11 November 2024

Submission on Hunter Indoor Sports Centre - SSD-65595459

Figure 2-15 Turton Road Shuttle Bus Zones along site frontage (MJ Stadium EMP TTP 2023)

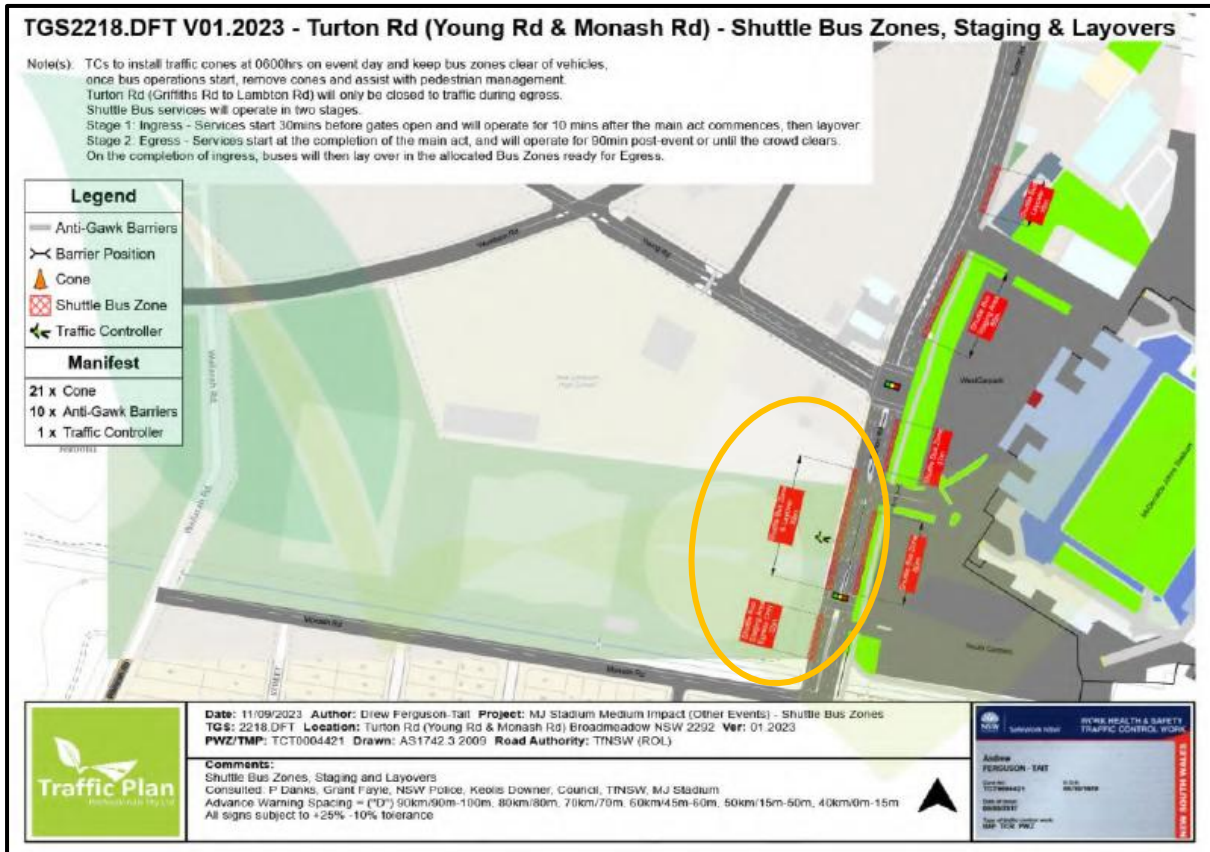
1. The Traffic Impact Assessment (TIA) does not include reference to the shuttle bus operation at McDonald Jones Stadium. Recommendation: The impact on the shuttle bus operations and shuttle bus drop-off locations needs to be analysed.
